Ribble Valley Borough Council
Housing & Development Control

Your ref: 3/2023/0549
Our ref: D3.2023.0549
Date: 10th August 2023

Application no: **3/2023/0549**

Address: **Thornley Hall Farm Up Bedlam Road Thornley PR3 2TN**

Drawing No: Air.1024.3350.02 **Drawn:** KA

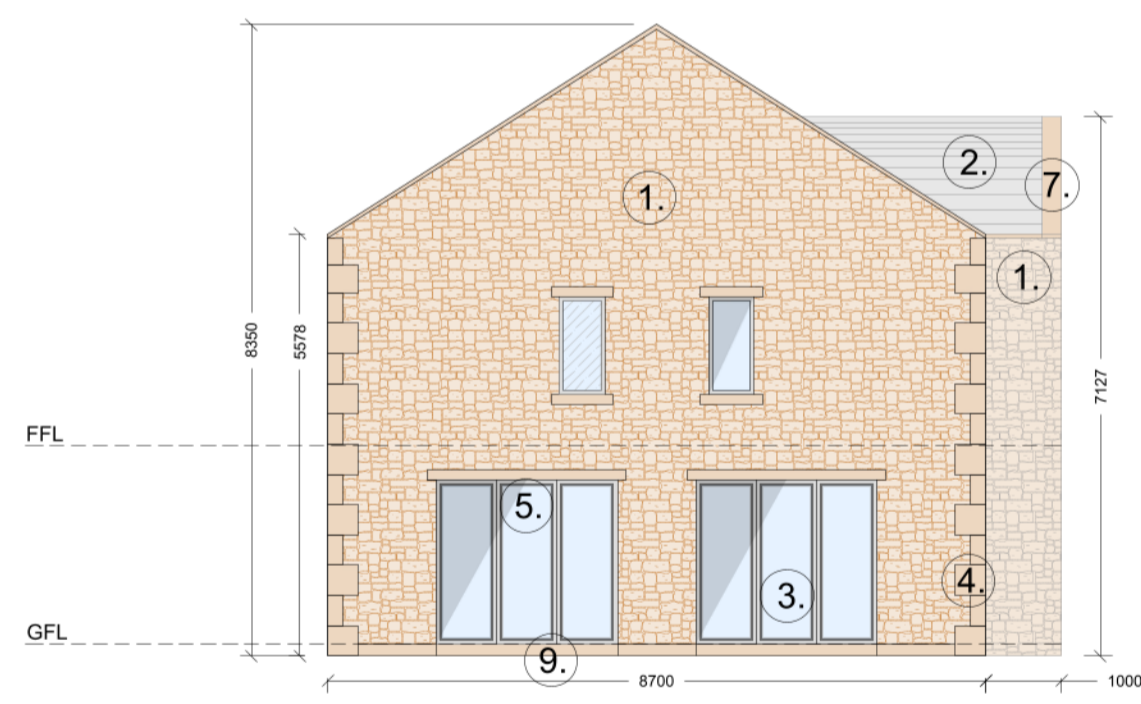
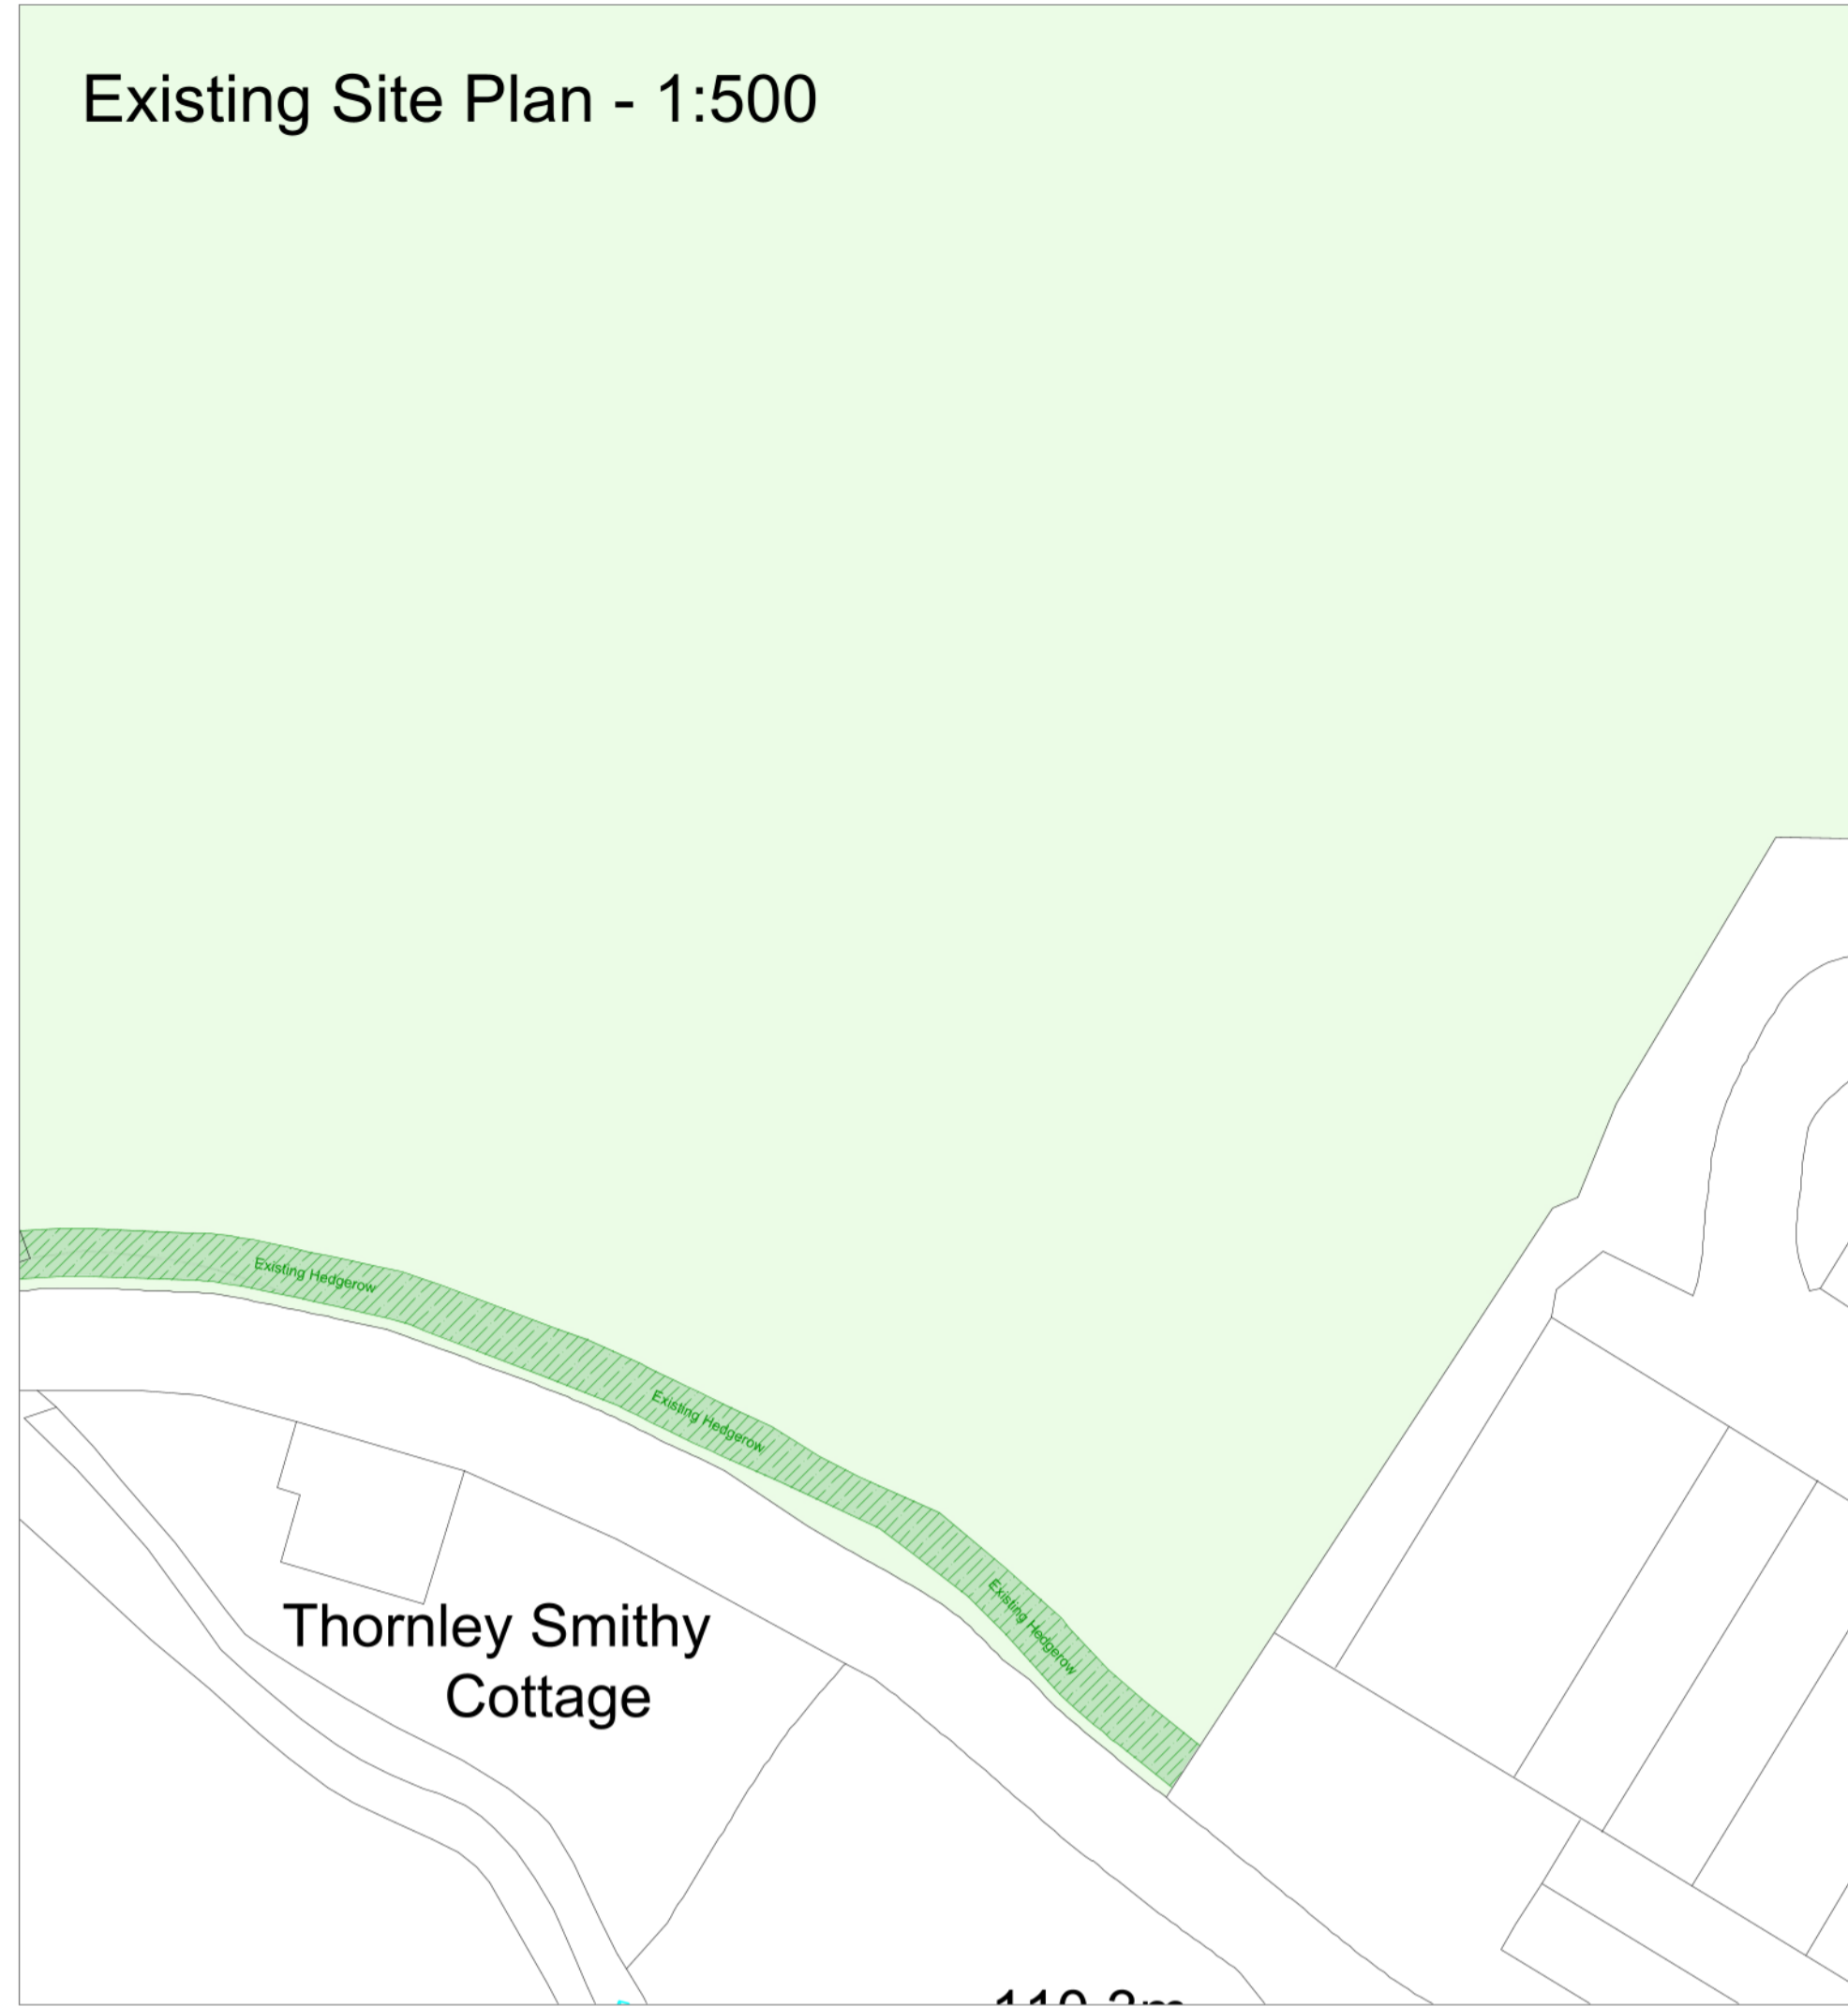
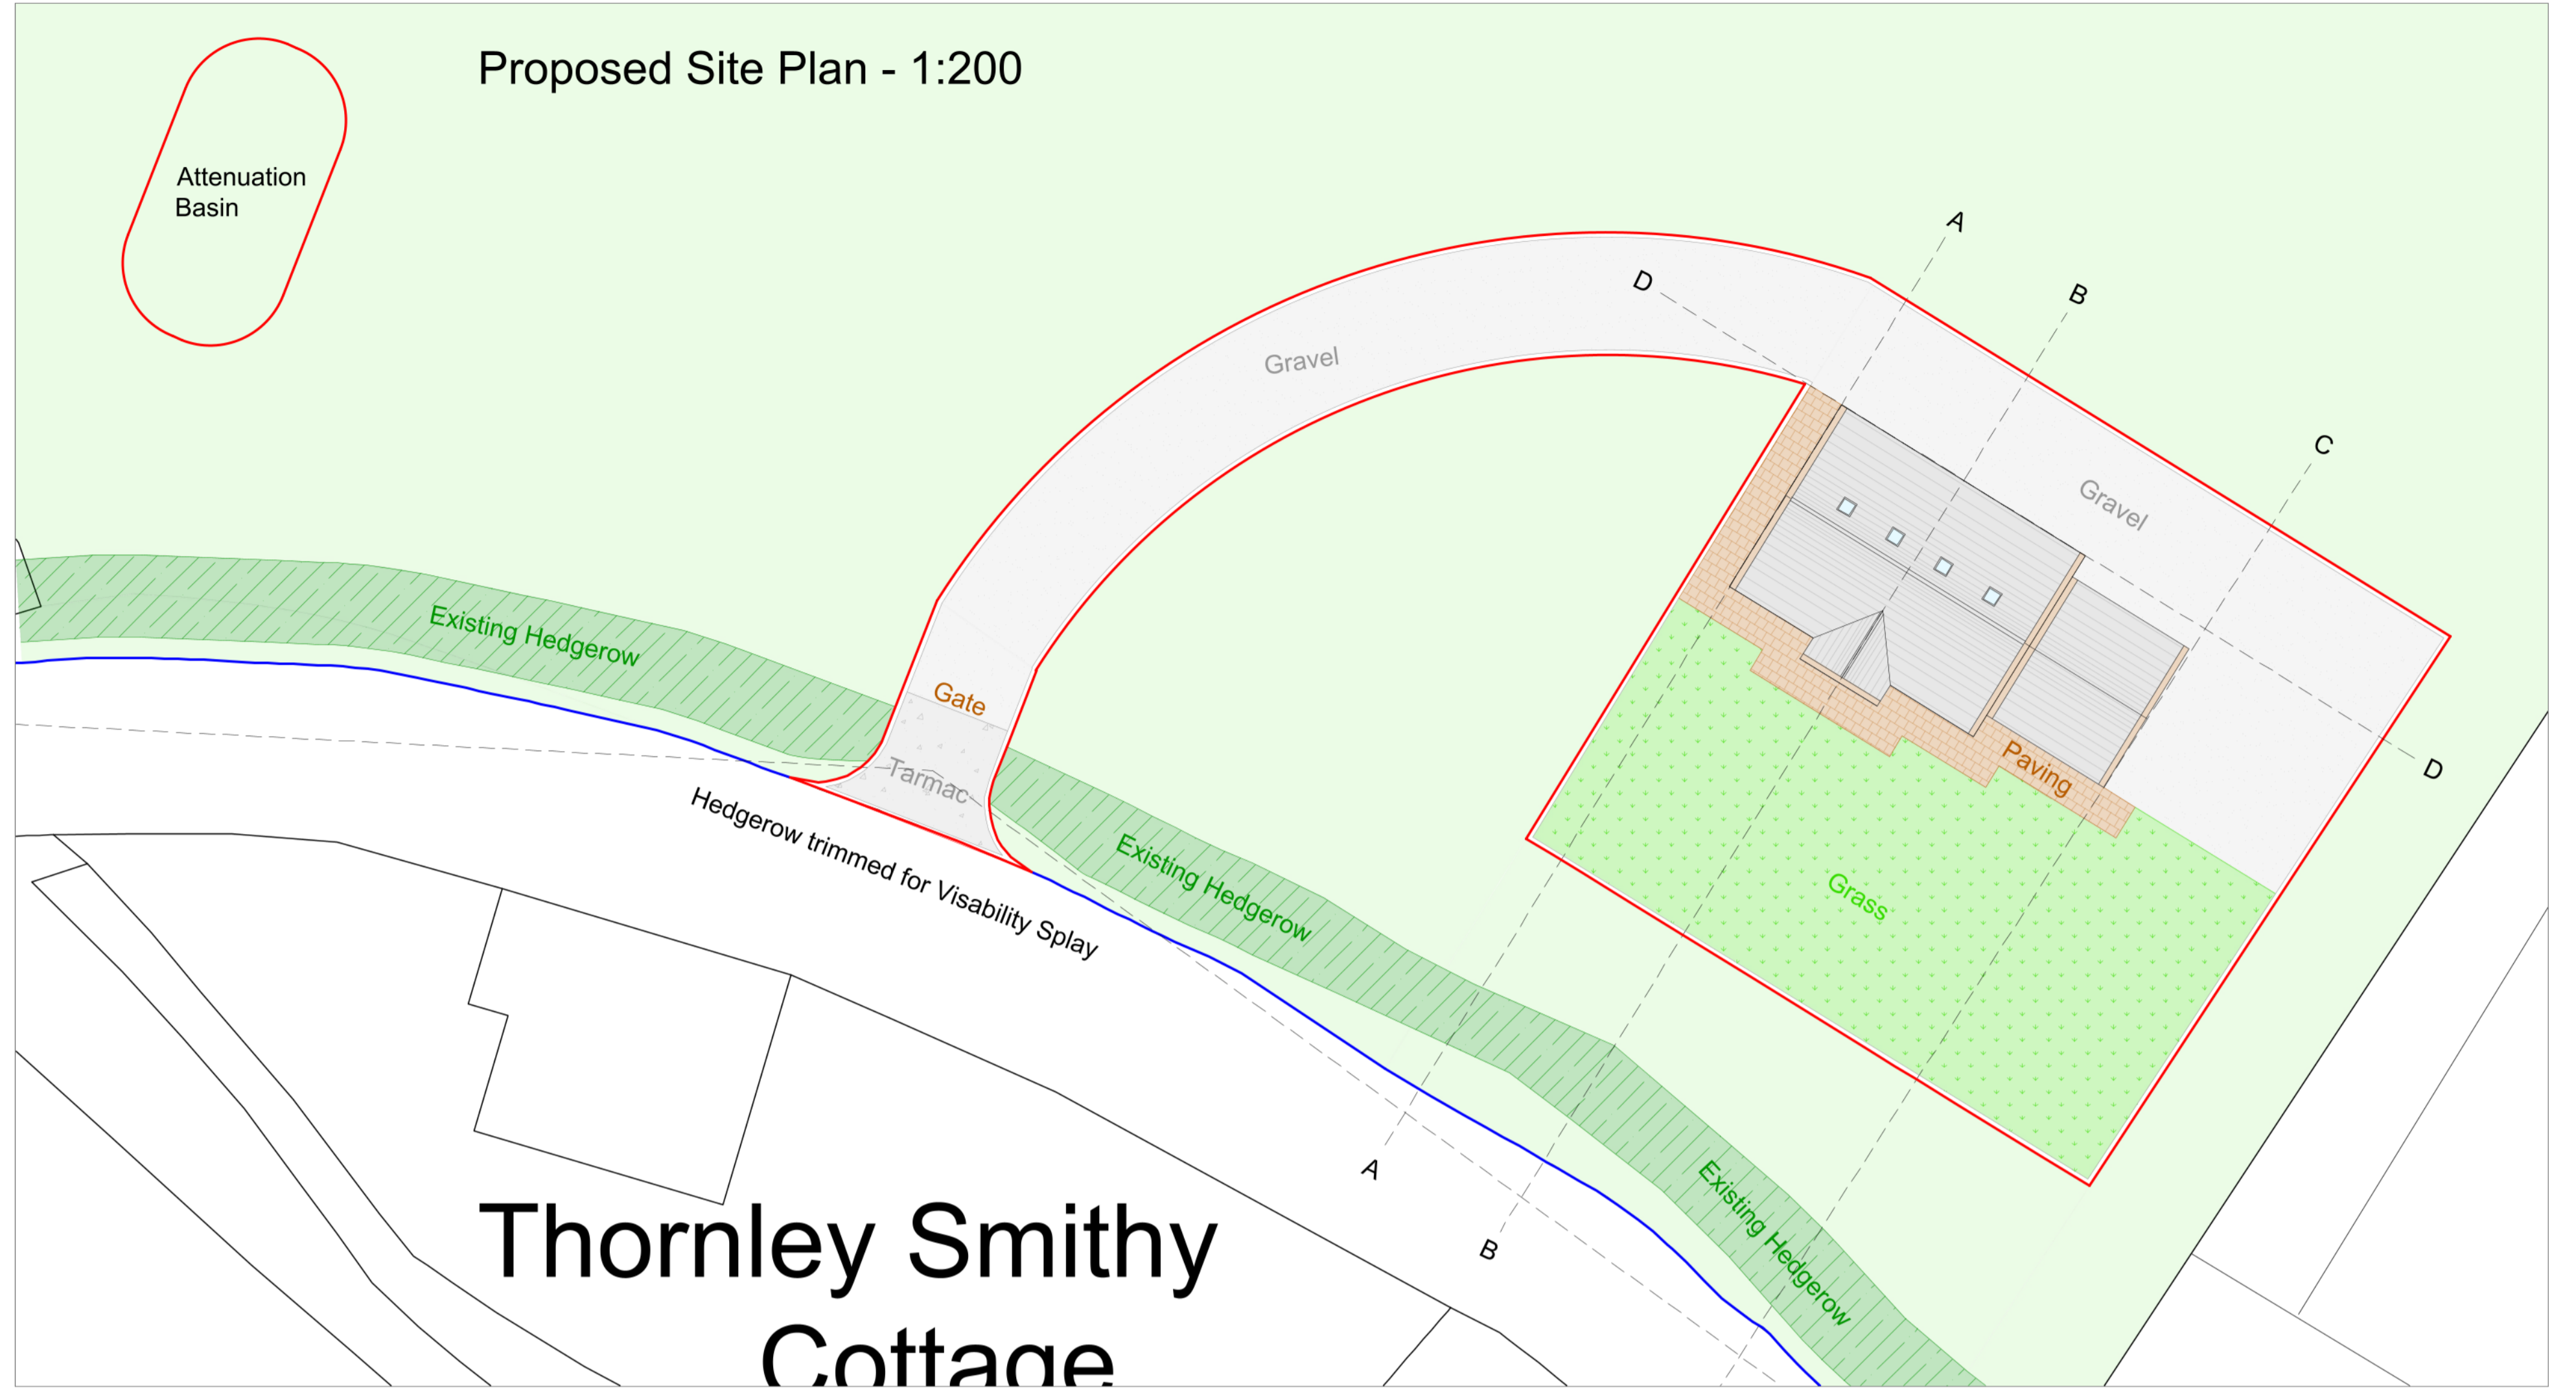
The LHA have reviewed GHA drawing number Air.1024.3350.02 titled "Proposed Plans and Elevations. Proposed Site Plan. Location Plan" and are aware that the proposed site access is the same as the access which was approved following outline application 3/2022/0265. Therefore, with there being no changes to the geometry or location of the site, the LHA have no objection to the proposal.

The LHA will however condition that a visibility splay drawing is submitted, and the hedge located within the visibility splays are permanently maintained. The LHA accepted visibility splays of 2.4m x 85m eastbound and 2.4m x 81m westbound following a speed survey which was conducted by the Transport Consultant for outline application 3/2022/0265. Therefore, these splays should be shown on a visibility splay drawing following the condition.

The LHA have reviewed GHA drawing number Air.1024.3350.02 titled "Proposed Plans and Elevations. Proposed Site Plan. Location Plan" and are aware that while no parking plan has been submitted there is ample space on site to provide a minimum of 3 car parking spaces to comply with the LHAs parking guidance as defined in the Joint Lancashire Structure Plan.

The LHA will condition that a minimum of one car parking space should have access to an electric vehicle charging point and a cycle storage facility should be provided.

3. No part of the development hereby permitted shall be occupied until such time as the access arrangements shown on GHA drawing number Air.1024.3350.02 have been implemented in full.

4. No part of the development hereby permitted shall be occupied until such time as vehicular visibility splays of 2.4 metres by 85 metres eastbound and 2.4 metres by 81 metres westbound have been provided at the site access. These shall thereafter be permanently maintained with nothing within those splays higher than 1 metres above the level of the adjacent footway/verge/highway.

6. The development hereby permitted shall not be occupied until such time as the parking and turning facilities have been implemented in accordance with GHA drawing number Air.1024.3350.02. Thereafter the onsite parking provision shall be so maintained in perpetuity.
